COMMENTS

5/21/02 Items # 1, # 2, # 3 (4/5/02) - Work Complete
Close out (D)
374-B-8
145 Auburn St.

Plot Plan

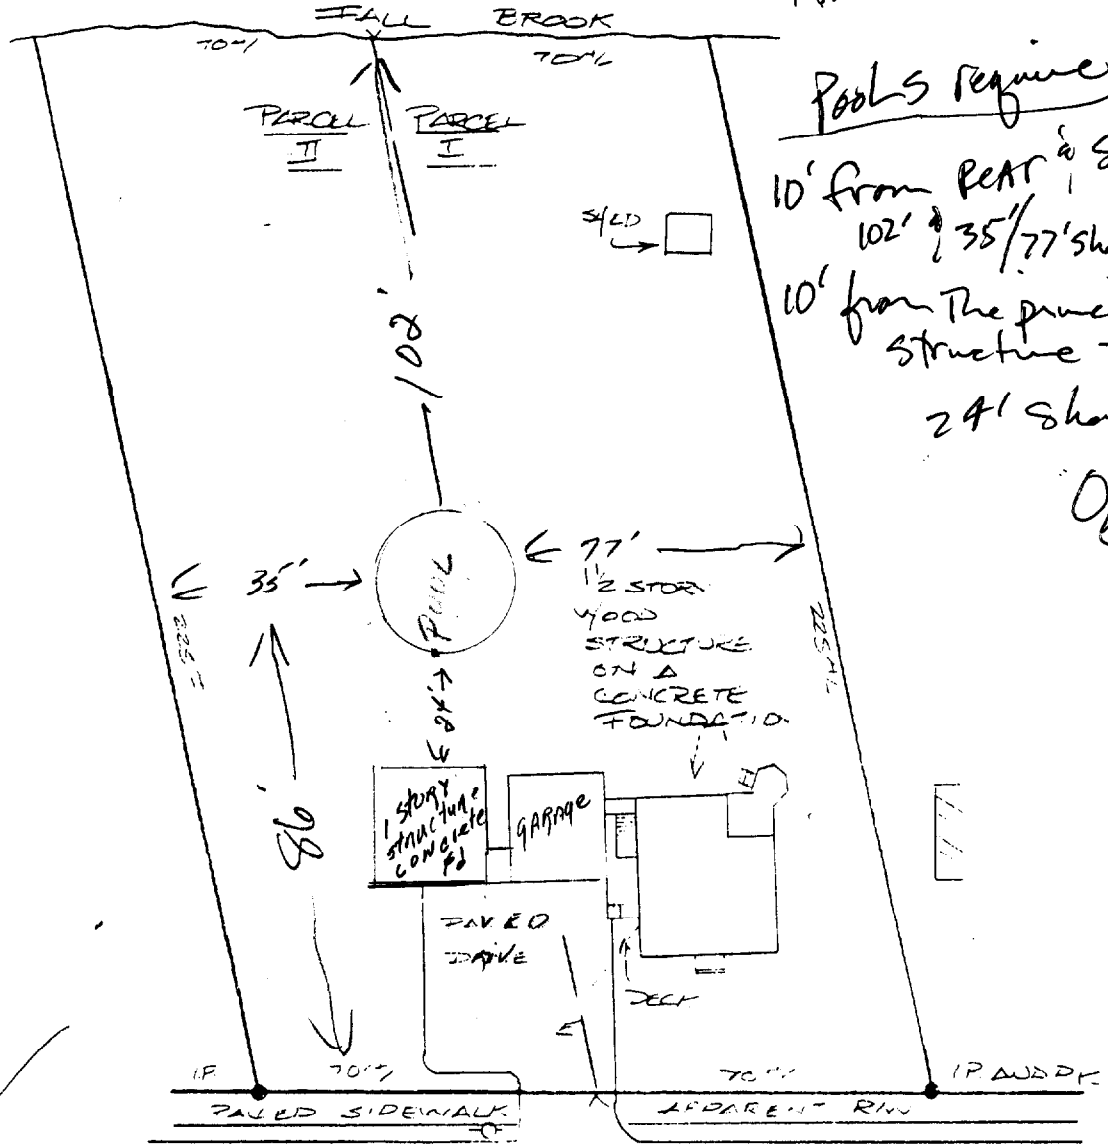
4/5/02 - ① Front Left Side of Pool Does NOT meet 48" Requirement
② Deck has been added w/o permit
③ Stairs to pool has NO protection (E)

4/8/02 - Owner submitted Ammendment for deck and ladder barriers for pool. Discussed area @ The pool 36" away from 48" pool wall to maintain 48" height JB
